PORTLAND MAINE

MEMORANDUM

DATE: July 17, 2013

SUBJECT: Bay House, Phase II – Preliminary Application

SITE PLAN
OF:
THE BAY HOUSE, PHASE II
NEWBURY / HANCOCK STREET
PORTLAND, MAINE
FOR:
113 NEWBURY STREET, LLC
35 FAY STREET, SUITE 107B
BOSTON, MA 02118-4320

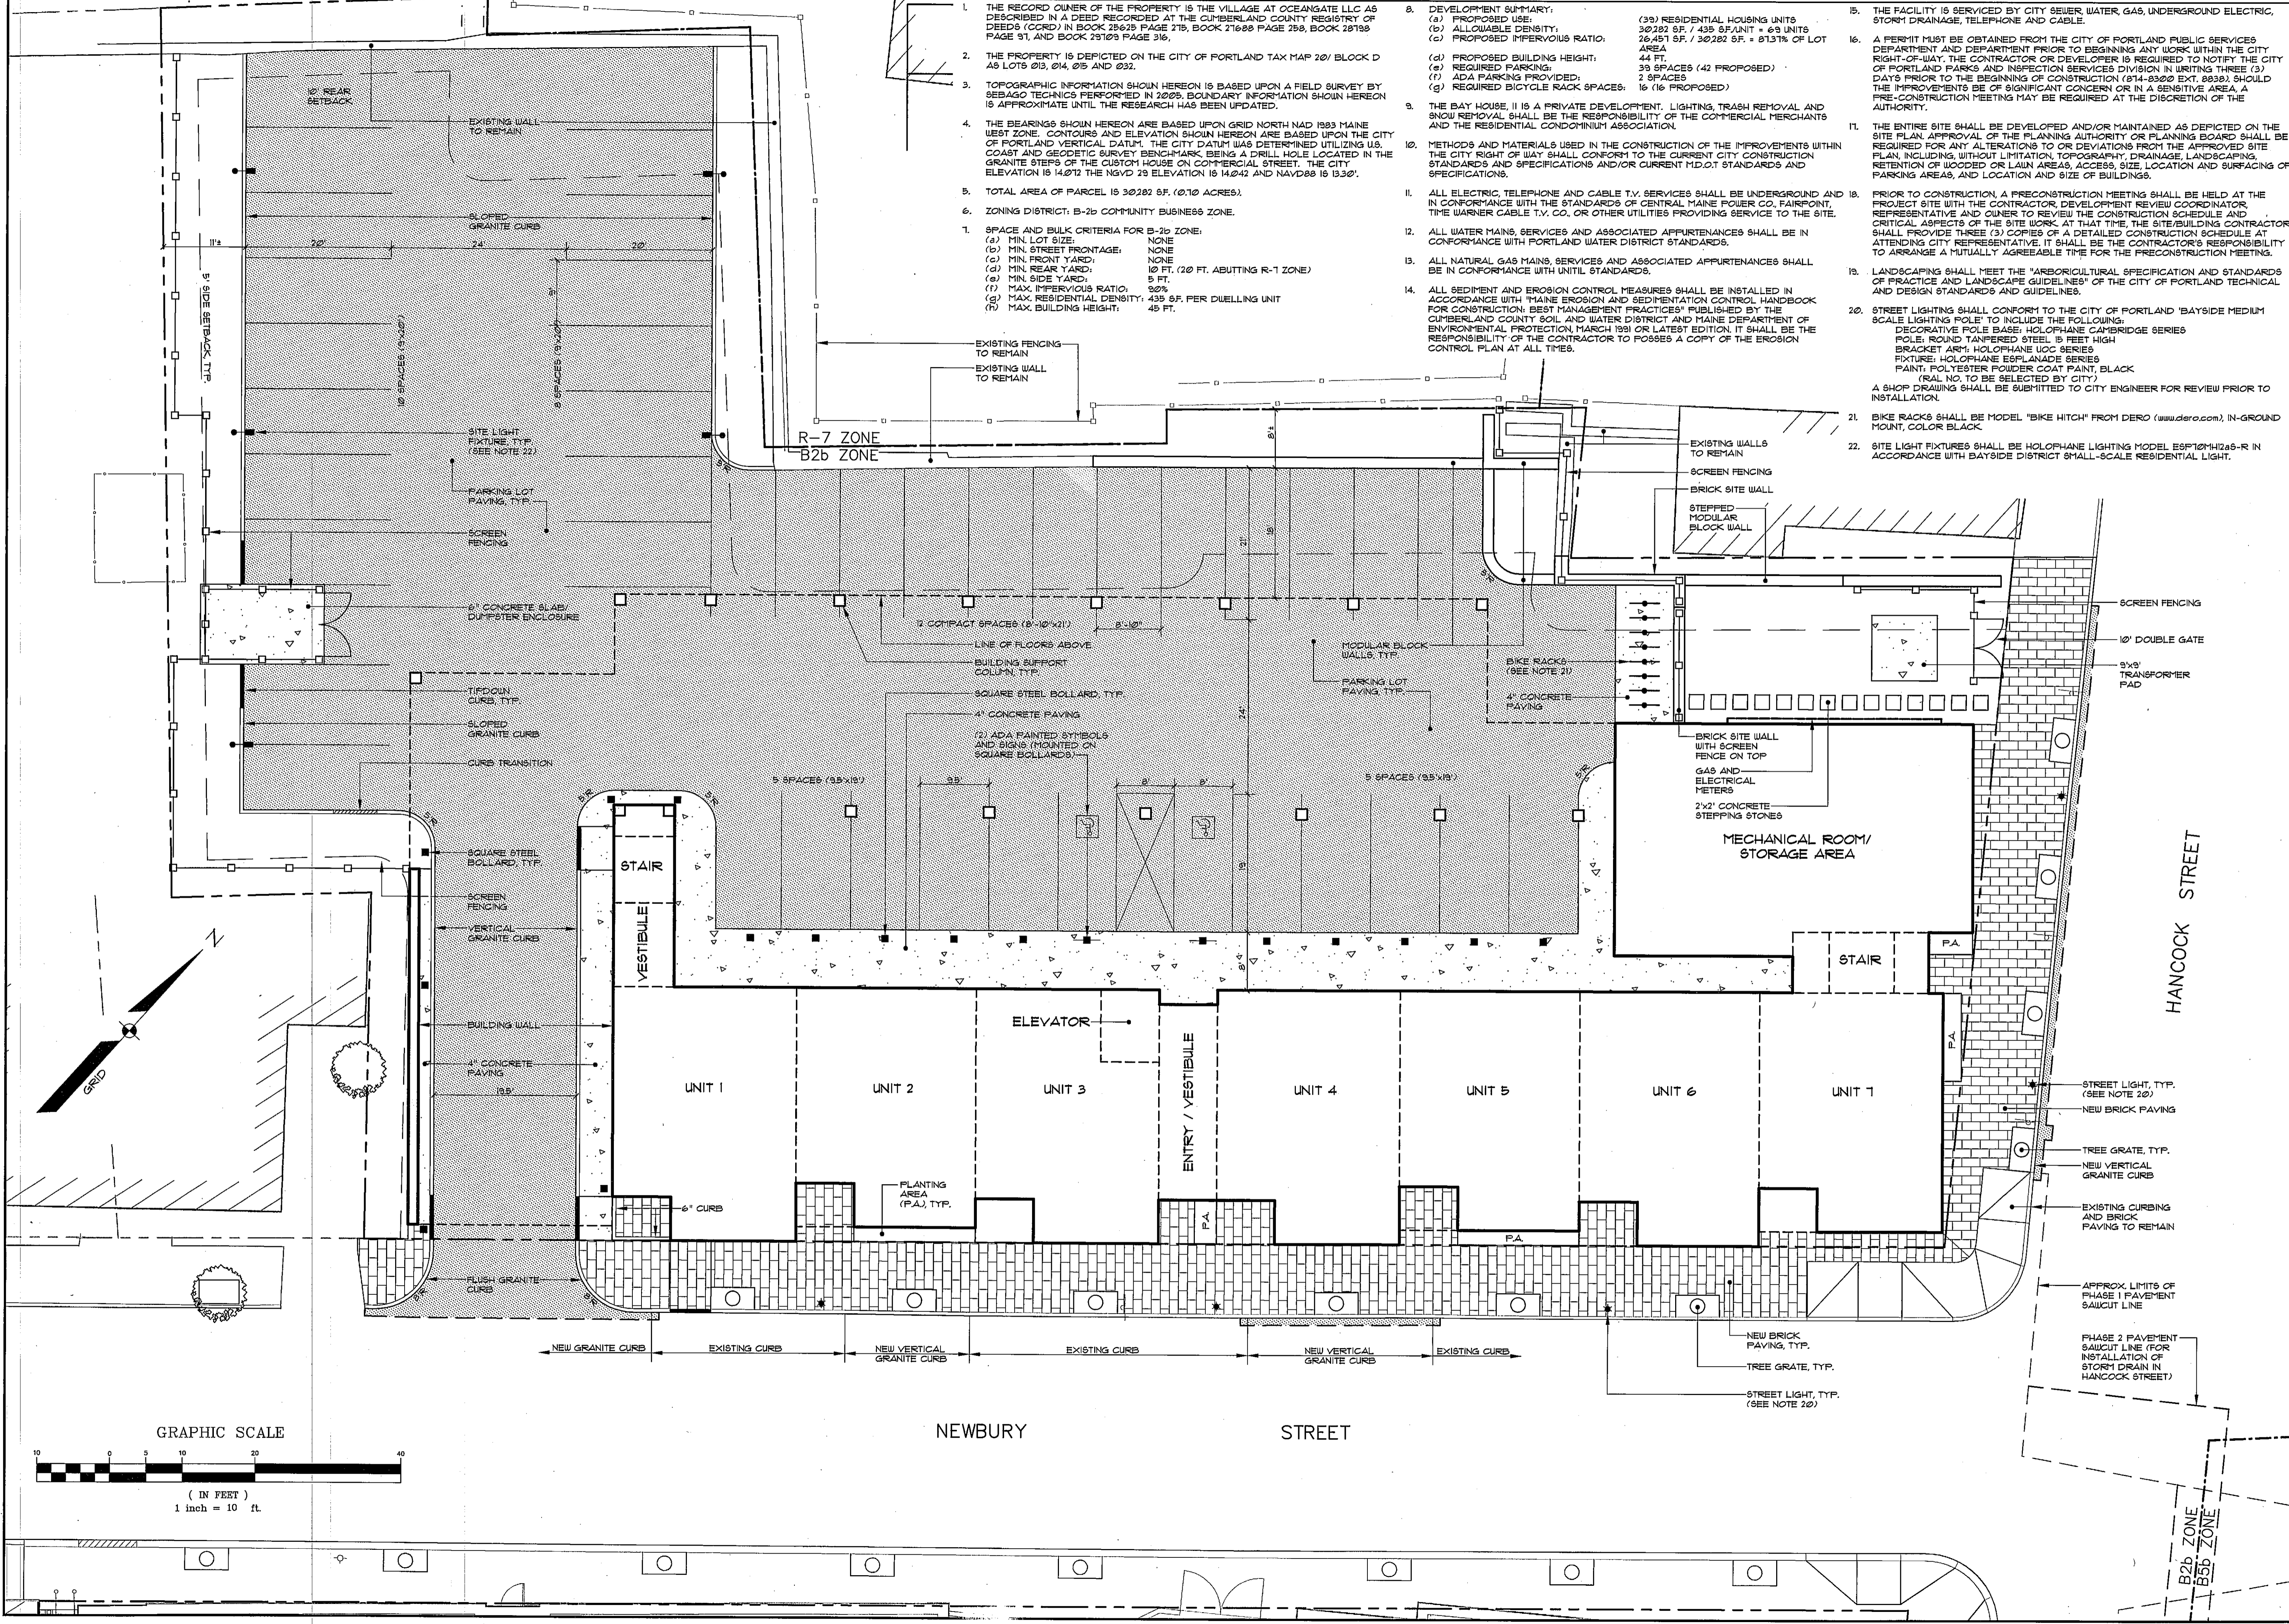
2. Current evidence of right, title and interest is required for the Phase II application. The amended plan in 2012 did not include Phase II.
3. The zoning assessment needs to present the proposed dimensional standards for the development compared to the zoning requirements. The site plans should indicate the distances of the building and pavement from property lines. In addition, please include a bar scale on the plans so that the site plans and elevation drawings, so Marge can calibrate the plans in e-plan and check for zoning compliance.

OFF-SITE DRAINAGE PLAN  
 OF:  
**THE BAY HOUSE, PHASE II**  
 NEWBURY/HANCOCK STREET  
 PORTLAND, MAINE  
 FOR:  
**113 NEWBURY STREET, LLC**  
 36 FAX STREET, SUITE 107B  
 BOSTON, MA 02114-4500

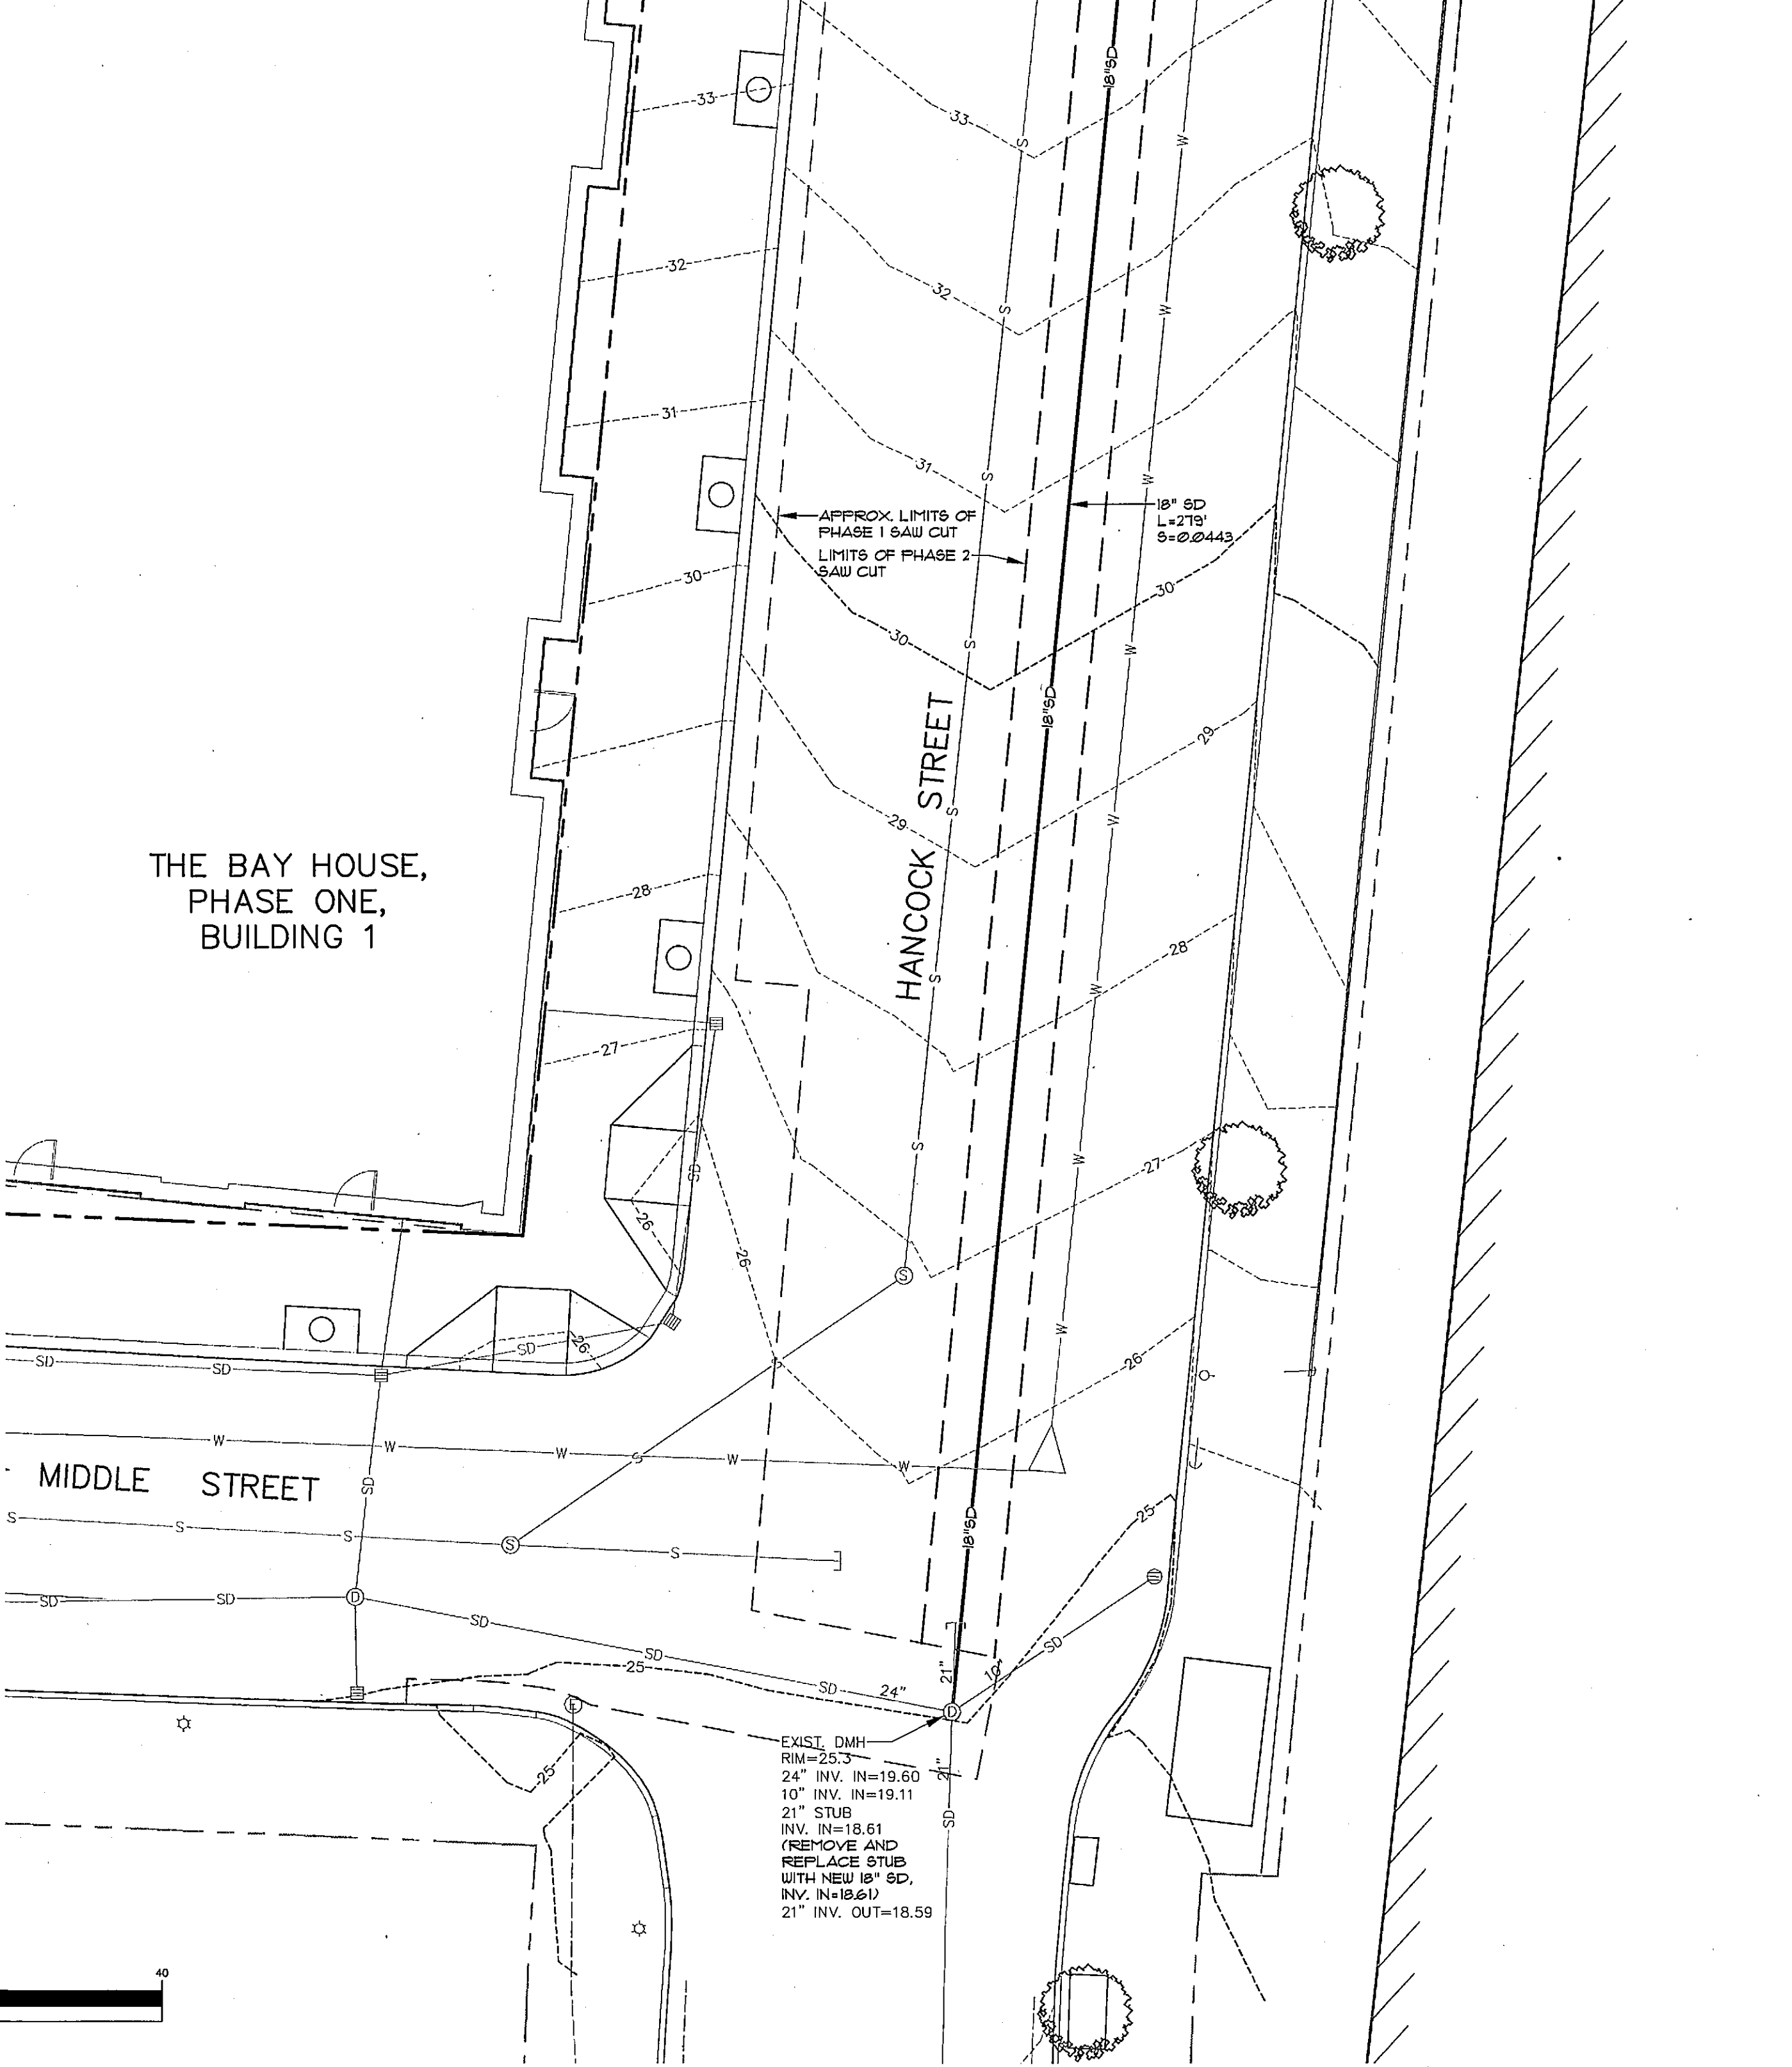
6. The cover letter states that evidence of financial capacity will be submitted at the time of final plan review, which is acceptable.
7. The site plan shows the proposed stormwater system. A narrative of the proposed system would be helpful in evaluating the adequacy of the system. It is stated that the storm water calculations will be submitted at the time of final review, which is acceptable.
8. Please note that the boundary survey plan must be stamped by a surveyor and the site plans are to be stamped by an Engineer for the final plan.
